Application Ref:	3/2020/1069	 <b>Ribble Valley Borough Council</b> <a href="http://www.ribblevalley.gov.uk">www.ribblevalley.gov.uk</a>
Date Inspected:	26.2.2021	
Officer:	LE	
<b>DELEGATED ITEM FILE REPORT:</b>	<b>Decision</b>

<b>Development Description:</b>	Proposed erection of a poly tunnel for plant growing
<b>Site Address/Location:</b>	Holden Clough Nursery Bolton-by-Bowland Road Bolton-by-Bowland Clitheroe BB7 4PF

Holden Clough Nursery - Proposed Poly Tunnel
Elevations
Scale 1:100 @ A3

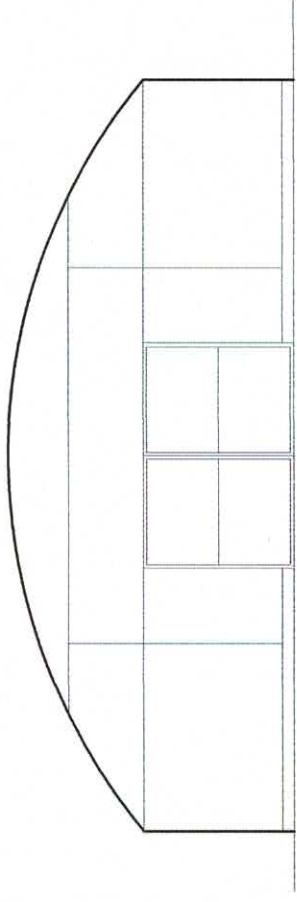
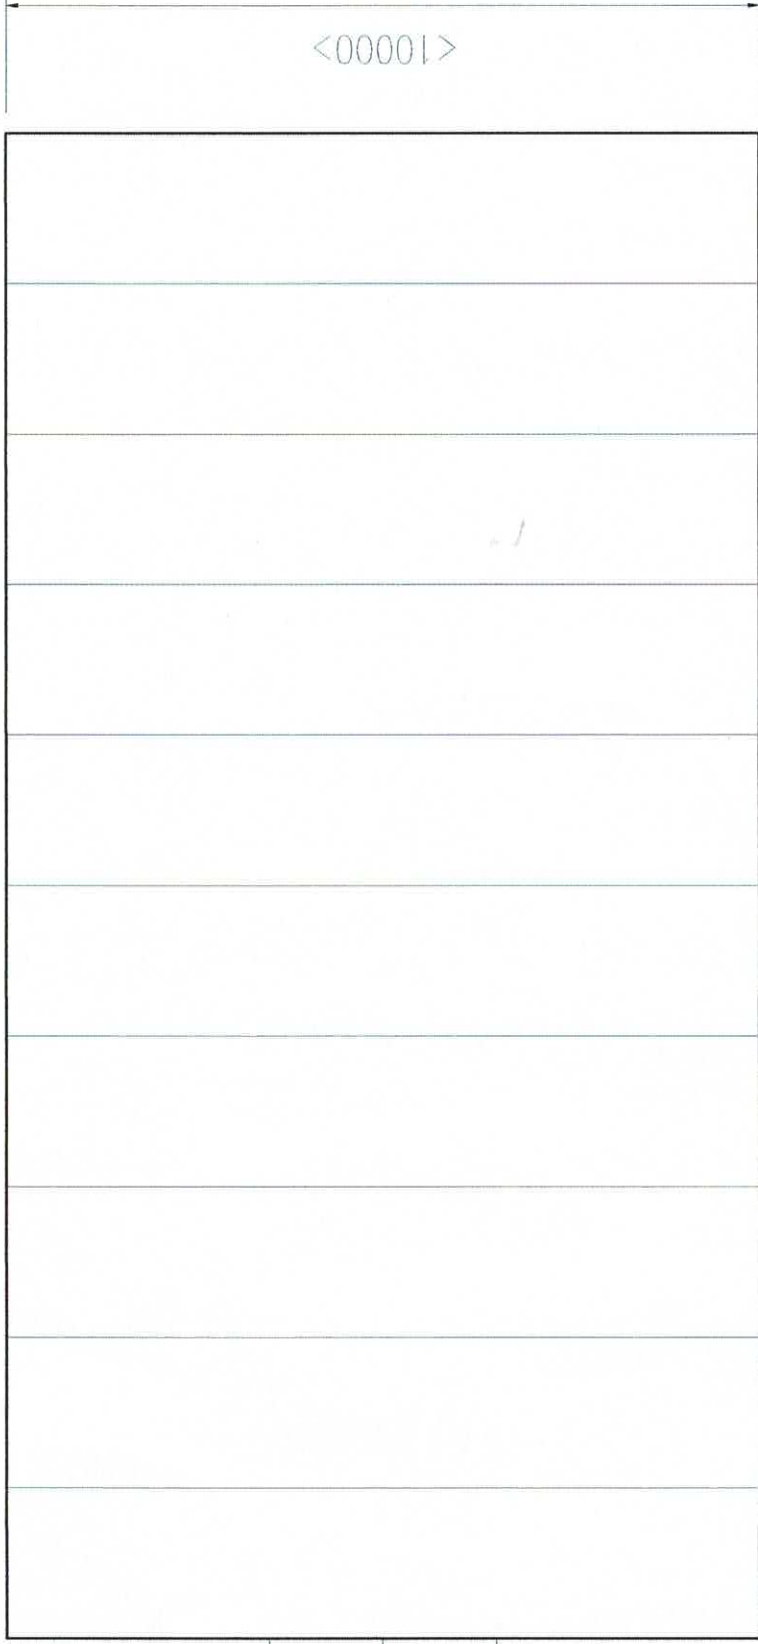
Holden Lane slopes upwards around the fields surrounding the site and affords uninterrupted views of the site from various elevated vantage points. The proposed poly tunnel measuring 20m x 10m in floor area and 3.8 metres high would be a significant incursion of built form and it is considered that there may be other areas within the site where it could be accommodated that would be more closely grouped to existing buildings. Due to the stark contrast of the colour and materials it would be very visible in long distance views. The applicant considers that the proposal will be in a suitable location along the screening that is to be planted around the car park. It is not considered that this is an acceptable solution to attempt to mitigate a harmful development, the views of it will be from higher land and the screen planting would not be sufficient to hide the full height or roof of the polytunnel. The submitted information fails to provide an adequate justification for the proposal.

Whilst its function may be for horticulture which is an appropriate use in the countryside, it will be an isolated and strident feature at odds with the pattern of development and landscape character of the AONB.

For the reasons discussed above the proposal is considered to be unacceptable in terms of its permanence, scale, siting and materials and will have a harmful impact on the landscape character of the Forest of Bowland AONB, setting of listed buildings and the character of the hamlet. Therefore it is recommended accordingly.

Holden Clough Nursery - Site
Plan
Proposed Poly Tunnel
Scale: 1:500 @ A3

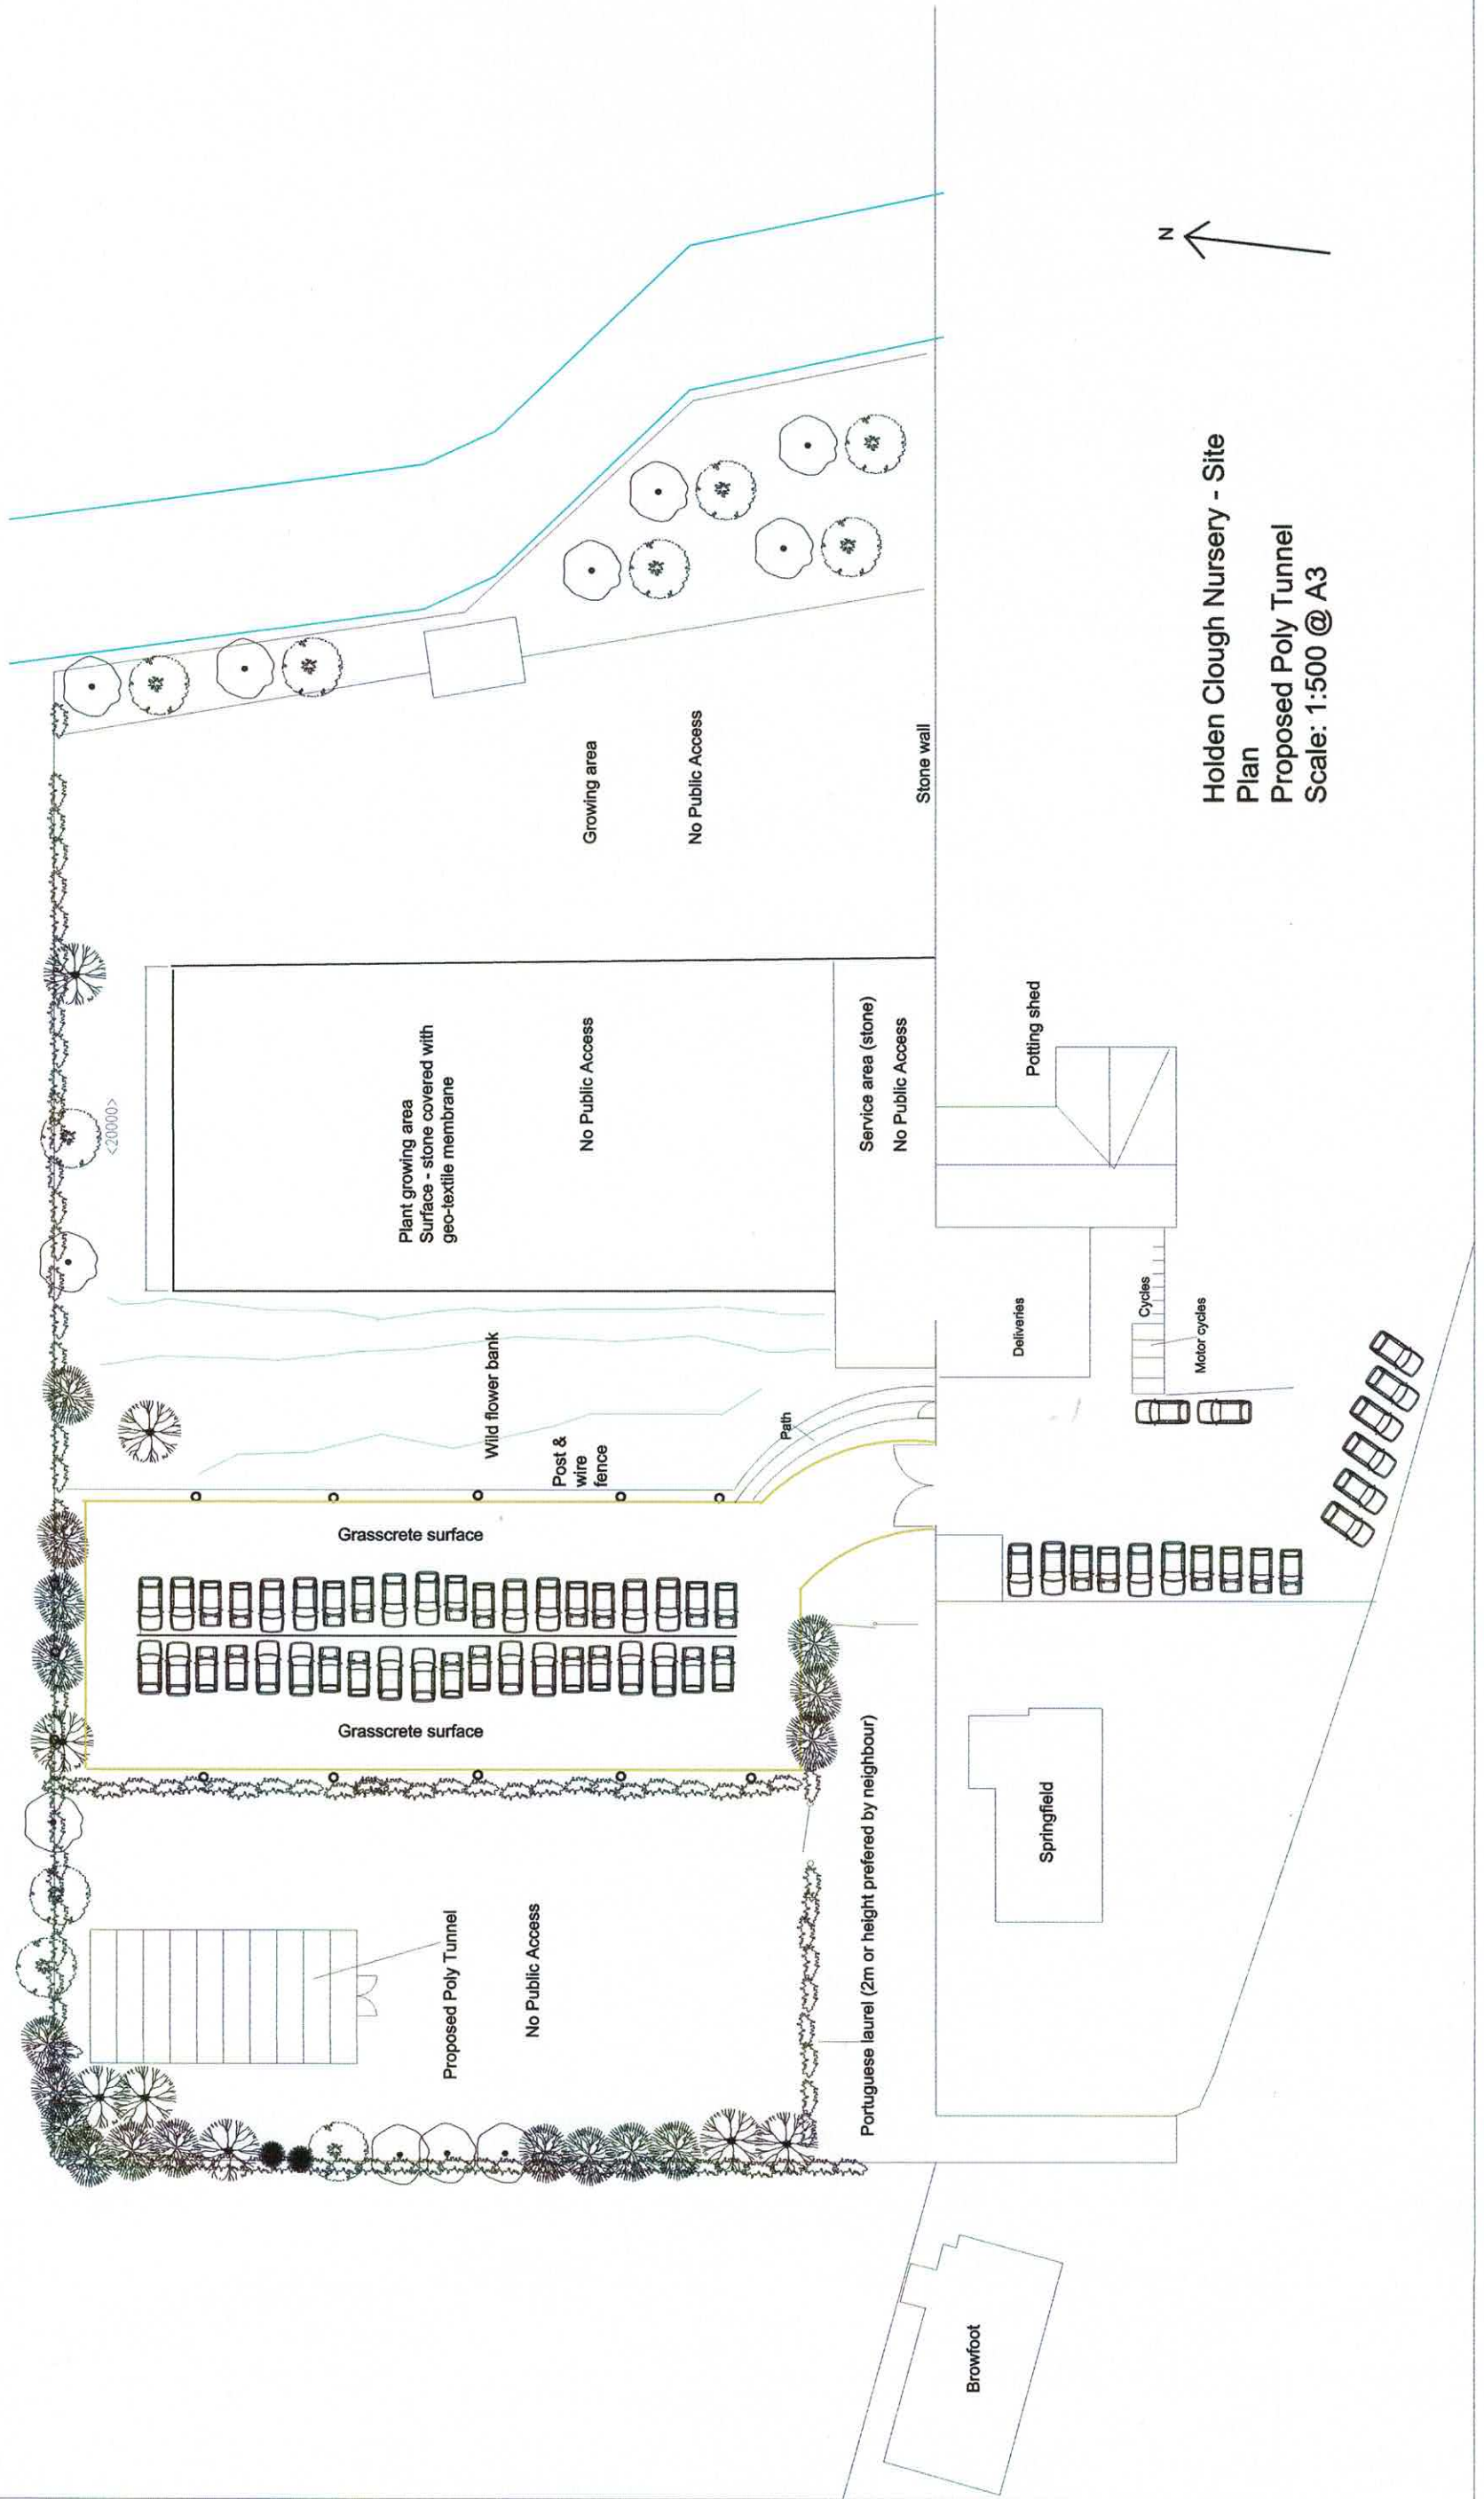
The use of the site for growing has been accepted previously and the main consideration here is the impact of the structure on residential amenity. The polytunnel will be located approximately 40metres from the rear boundary of Springfield so whilst undoubtedly it will be visible from the garden of this property it is not considered that there would be an unacceptable impact on residential amenity through loss of privacy, or overshadowing given that the area is already used for growing plants and will not be accessible for members of the public. Furthermore screen planting is proposed to the southern boundary, which will mitigate the impact on outlook. There have been concerns raised with relation to noise which are noted however there could potentially be machinery accessing the site at present when it is in use as an open growing area, the screen planting may provide some form of barrier to any noise emitted which is likely to be in daytime hours only. Lighting, access for staff only and hours of operation could be controlled by condition if the proposal were considered generally acceptable.

It is appreciated that the location may have been selected to attempt to reduce the impact on the amenity of nearby residents and keep it within a separate area from the side of the business where members of the public are present. However due to its position isolated from the existing built form and the linear form of the development in the hamlet; the proposal raises the same objections in terms of visual impact as the previously refused scheme. There have been a number of applications approved in recent years for expansion of the business and this continued encroachment would lead to sprawl and be disproportionate to the hamlet within which it is located.
